DA Access Report

*Telopea Estate – Stage 1A
Lot 5-7 of Masterplan,
Telopea NSW 2026*

Prepared for
Frasers Property Australia

8 July 2021

DRAWING TITLE
**LOWER GROUND FLOOR
PLAN**

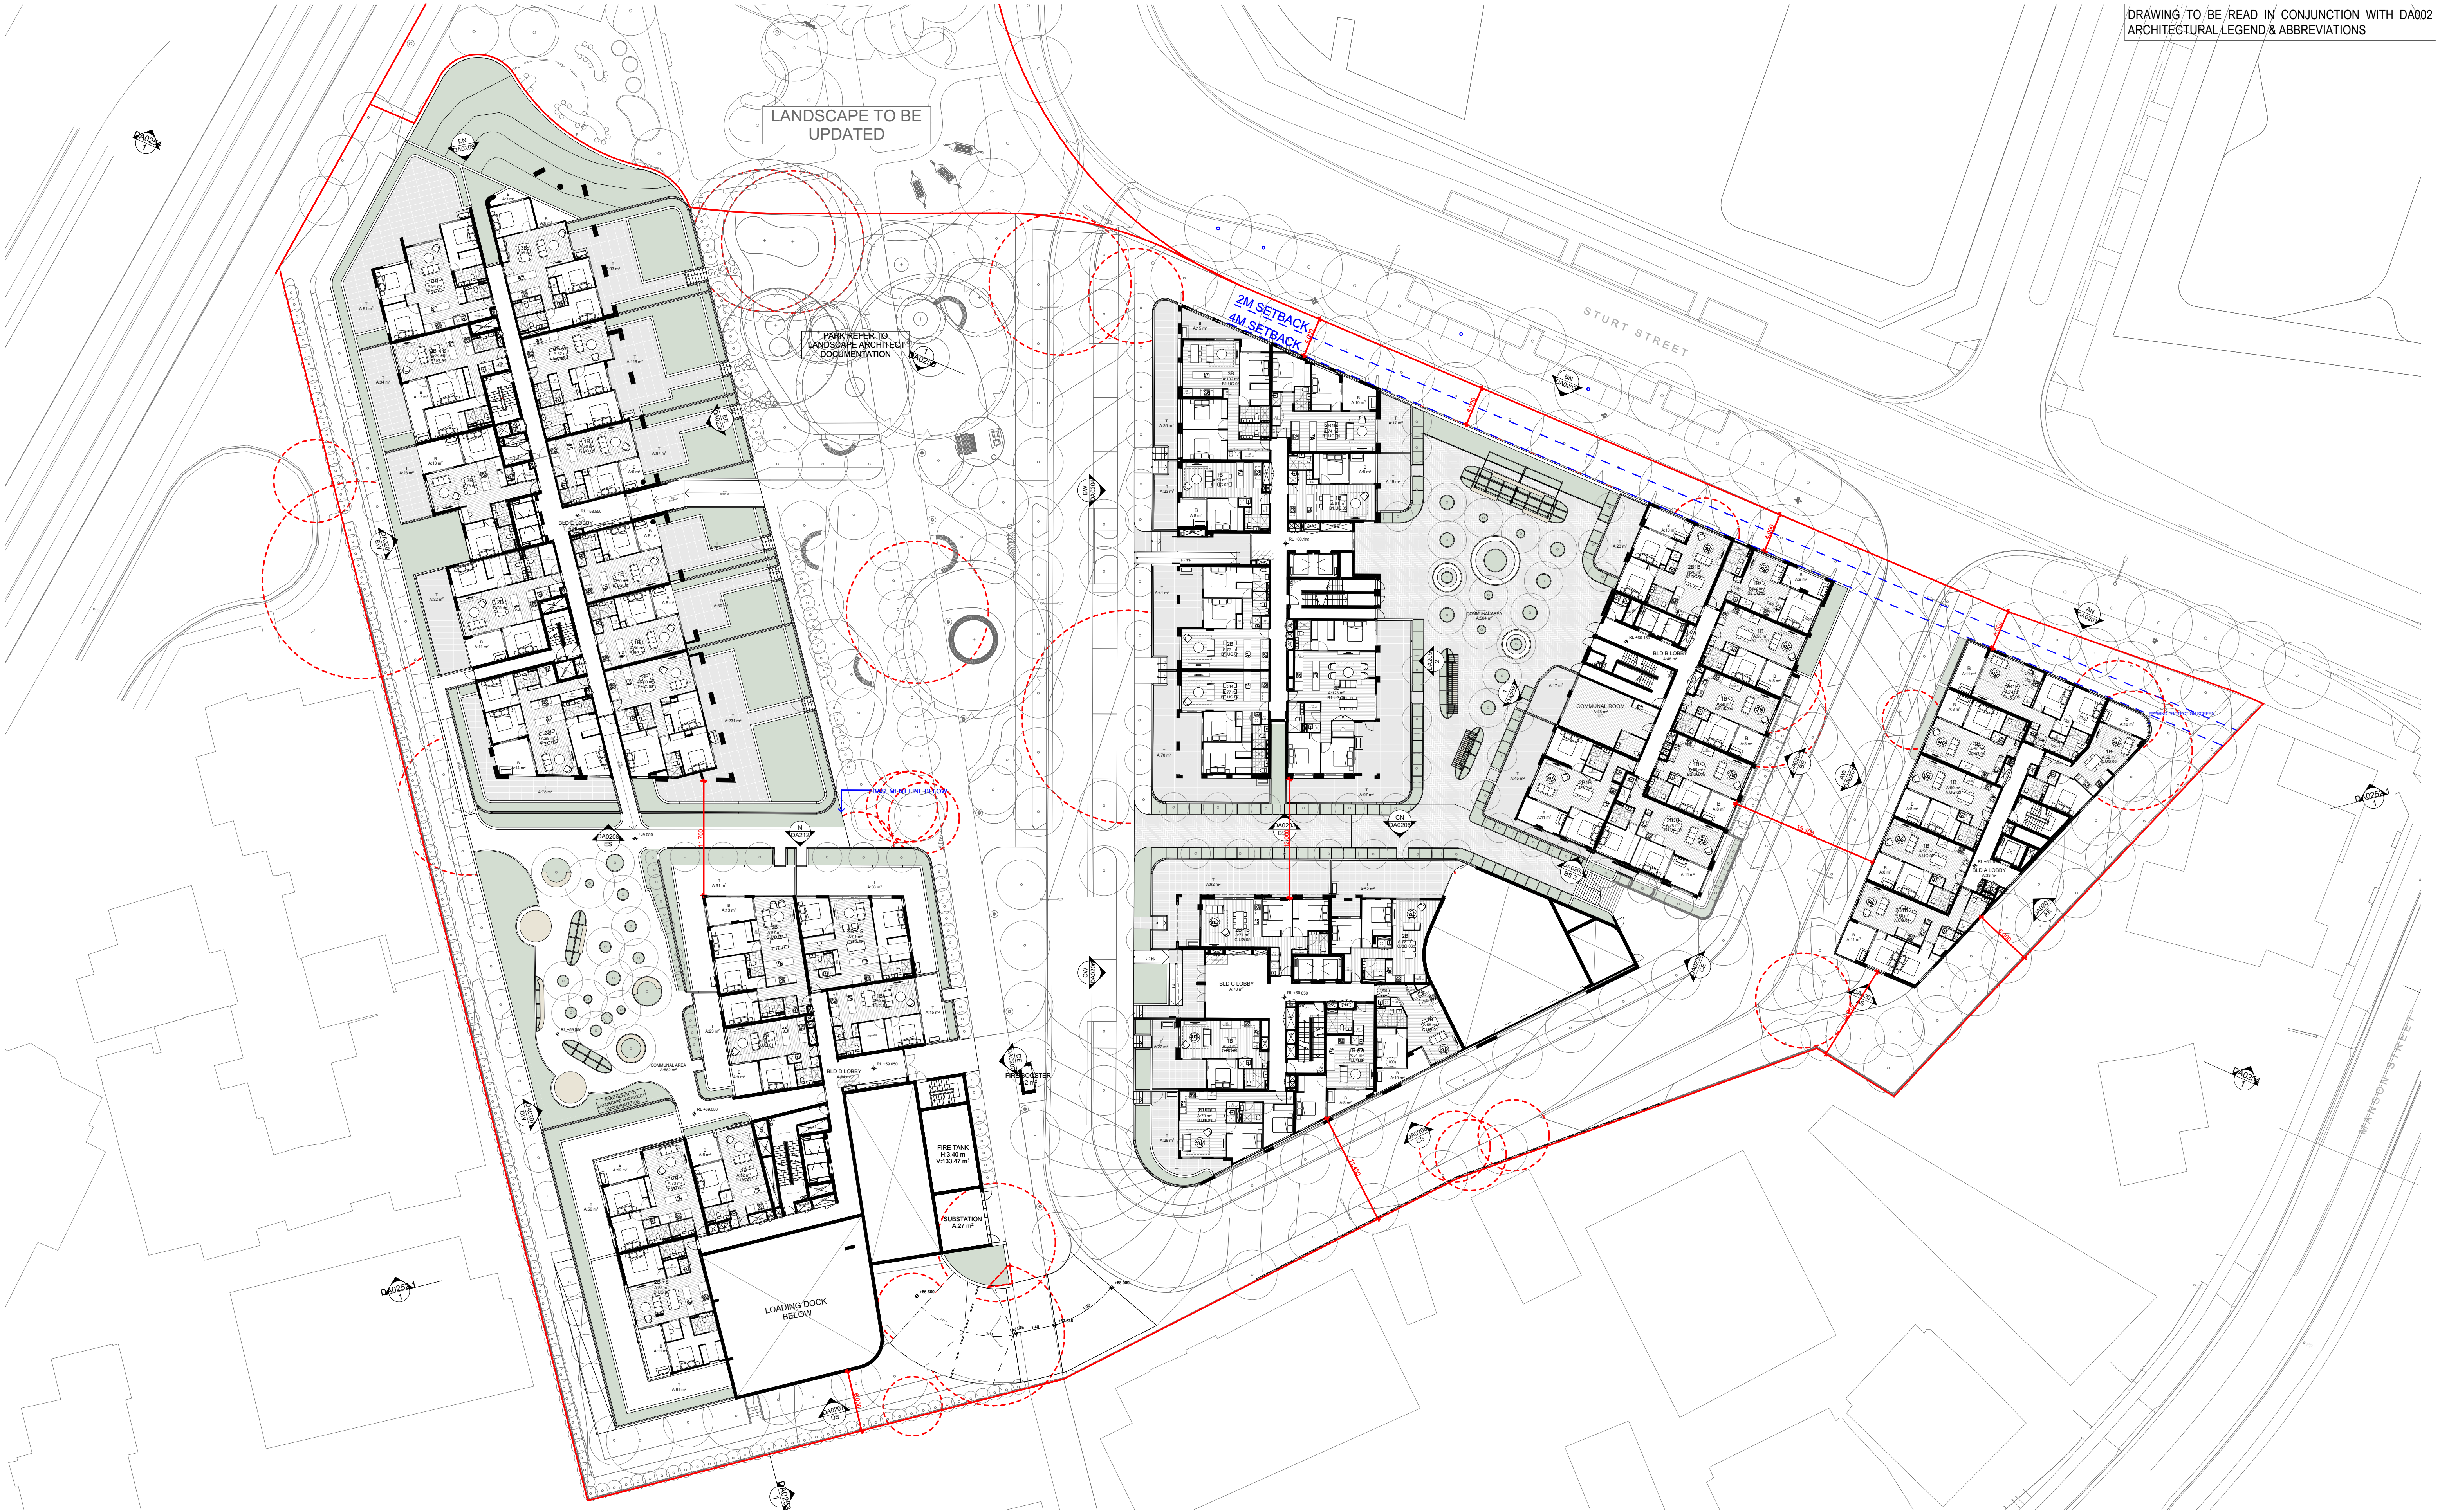
There is stairway access located from the internal street to Building B lobby. The accessible entry is located on Stuart Street via a 1:14 grade ramp. The ramp is located 25m from the non-accessible entry. Consideration is required to ensure the accessible entryway is designed as the primary access way in accordance with the Disability (Access to Premises – Buildings) Standards.

A 1:14 ramp has been provided to the Building C lobby. Review is required to ensure the ramp is recessed from the pedestrian footpath to allow appropriate handrails and TGSIs. The dual-hinged lobby entry doors are to be recessed to allow for appropriate 1500mm clearance at the top of the ramp (clear of handrail extensions). The doorway to the lobby has suitable door clearances compliant with AS1428.1-2009.

Within the residential building, there is suitable access within residential corridors to all sole-occupancy units located within the building. Corridors generally achieve minimum 1600mm clear widths with appropriate wheelchair turning areas located within the ends of corridors. Review is required of the end of corridor clearance in Building A, on Basement 01 which has 1200mm clearance.

- (i) Provide a minimum 1540mm by 2070mm clearance within 2m of the end of the corridor of Building A, Basement 01;
- (ii) Ensure all common areas and car park lobbies have level access from the residential lobby;
- (iii) Common area doors and gates require minimum 850mm clear widths and 530mm latch side clearances;
- (iv) Ensure all common area stairways have appropriate handrails and TGSIs; and
- (v) Ensure all fire egress stairs have appropriate handrails and nosings in accordance with the NCC.

DRAWING TITLE
LEVEL 02 FLOOR PLAN

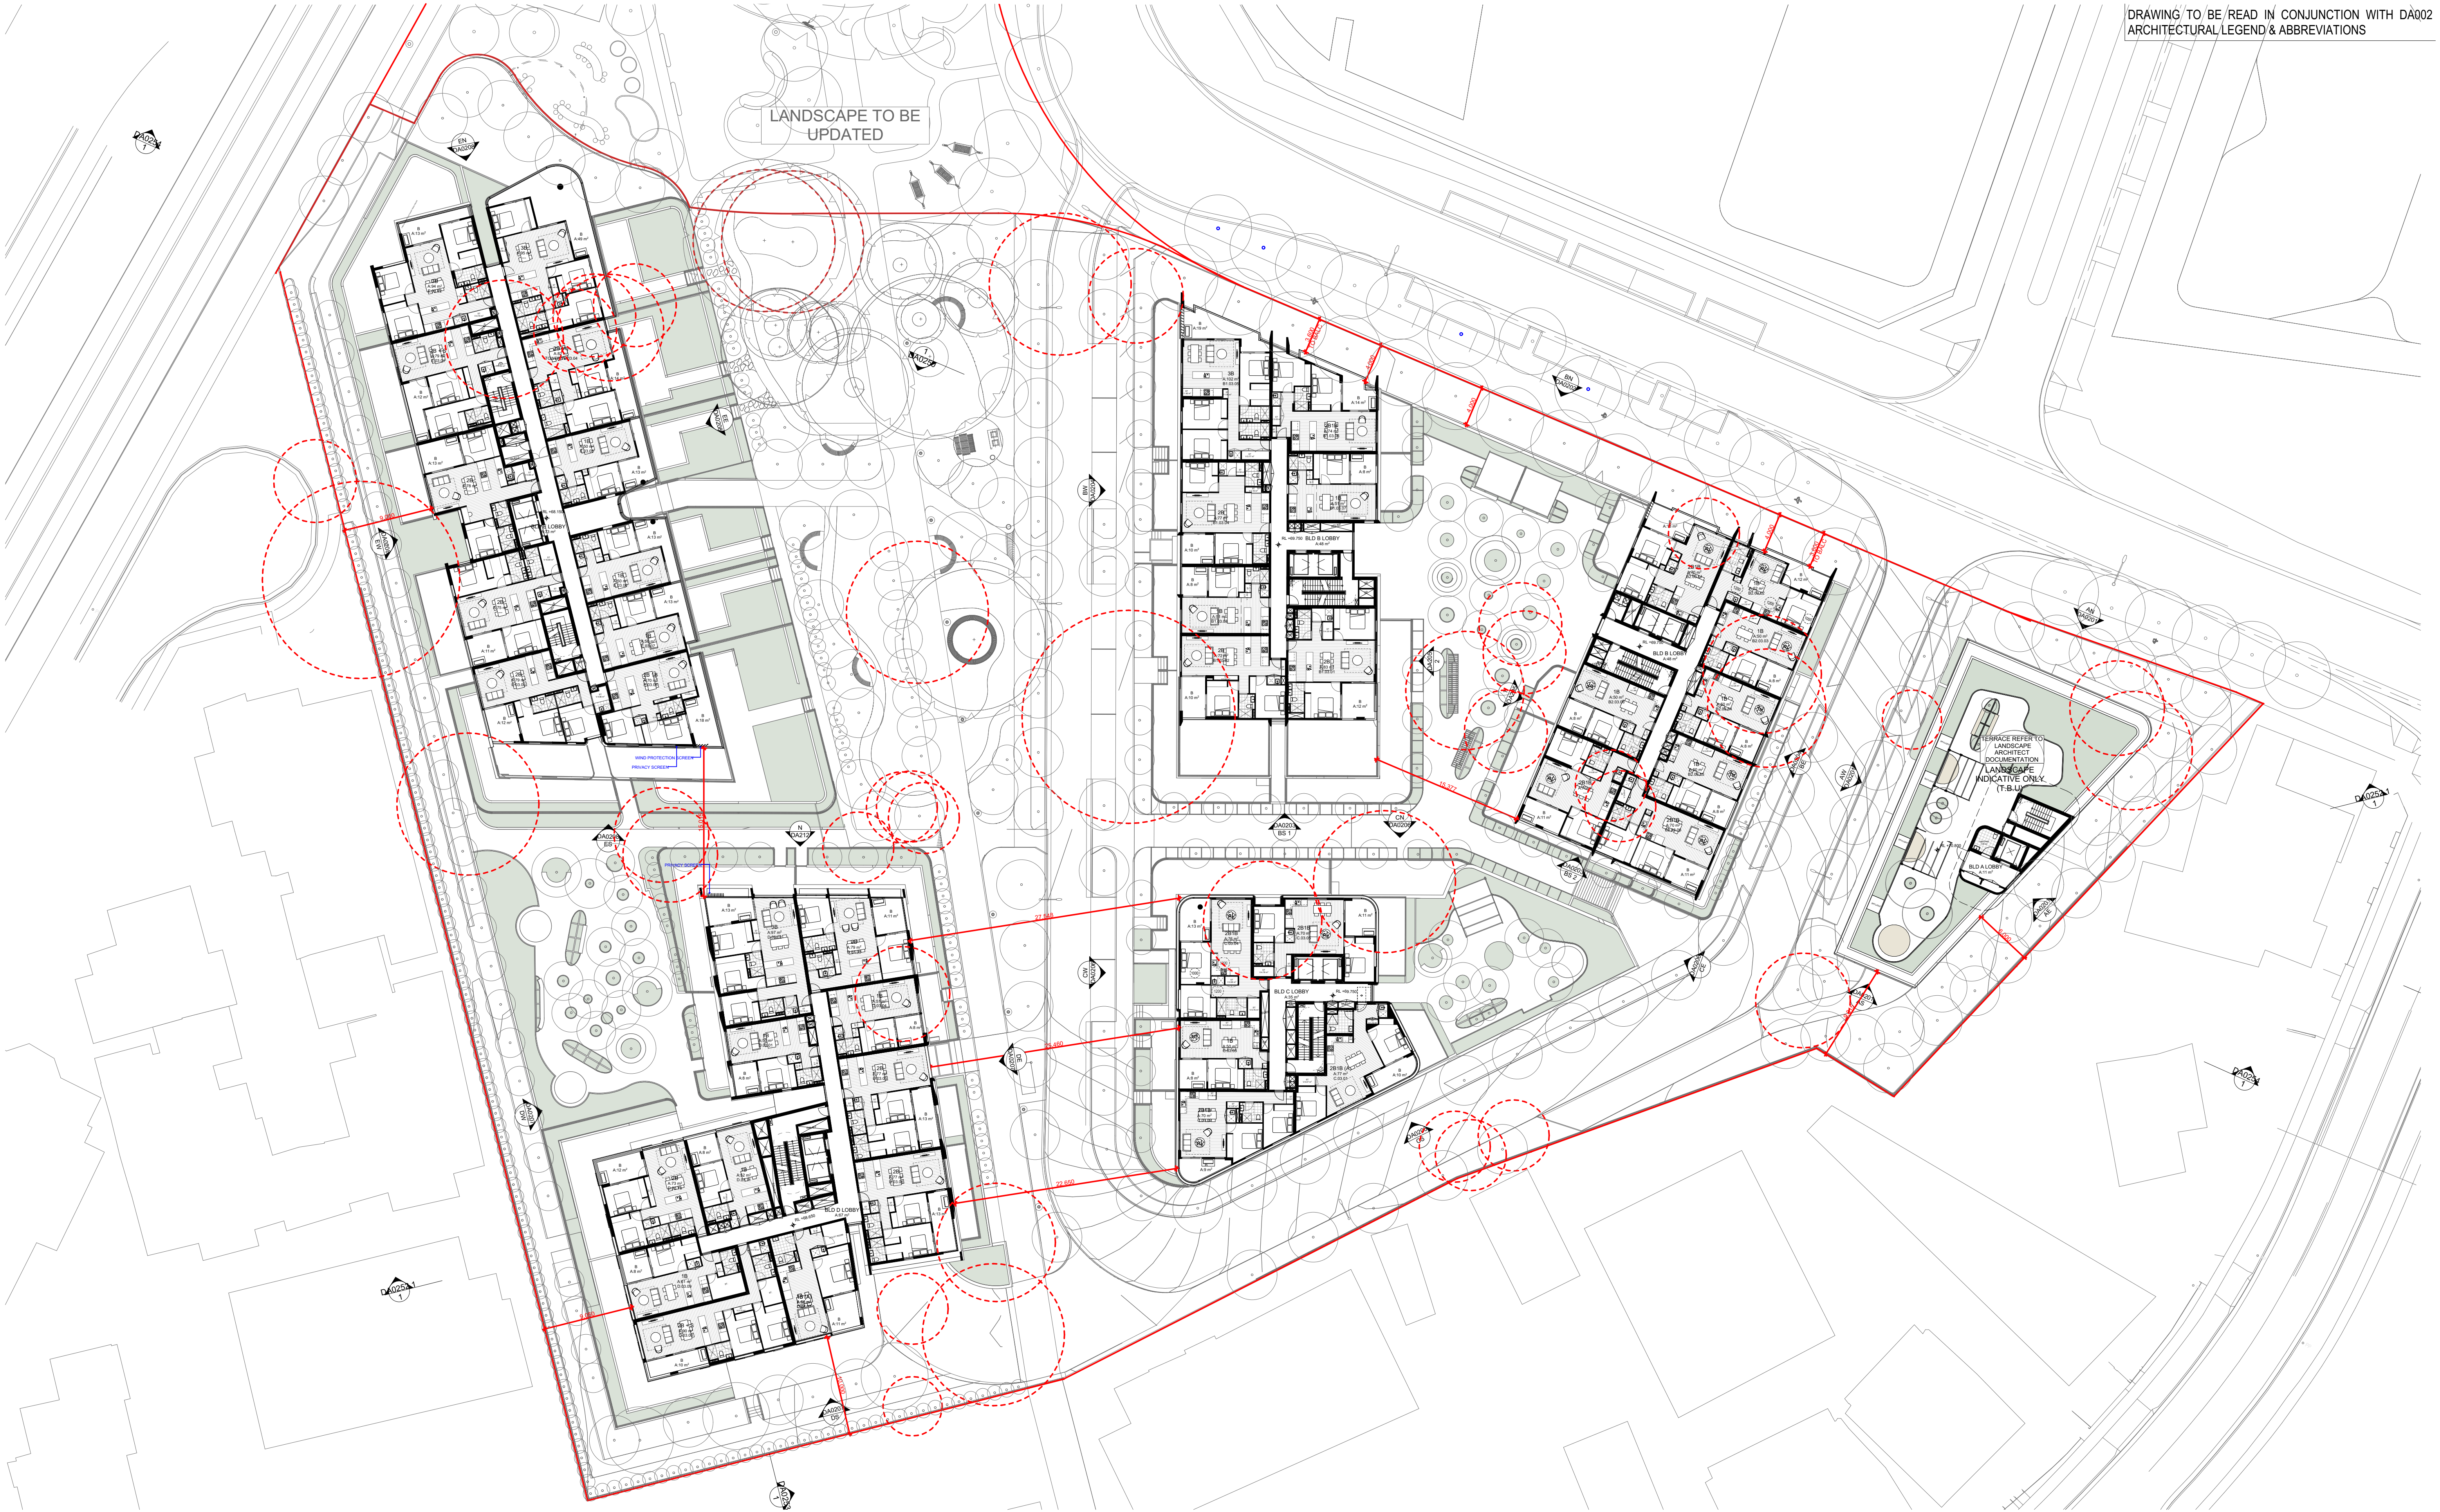
There is a terrace garden located on Level 02 of Building A with an adjacent sanitary compartment. Accessed via a hinged door, the accessible WC has appropriate internal dimensions compliant with AS1428.1-2009.
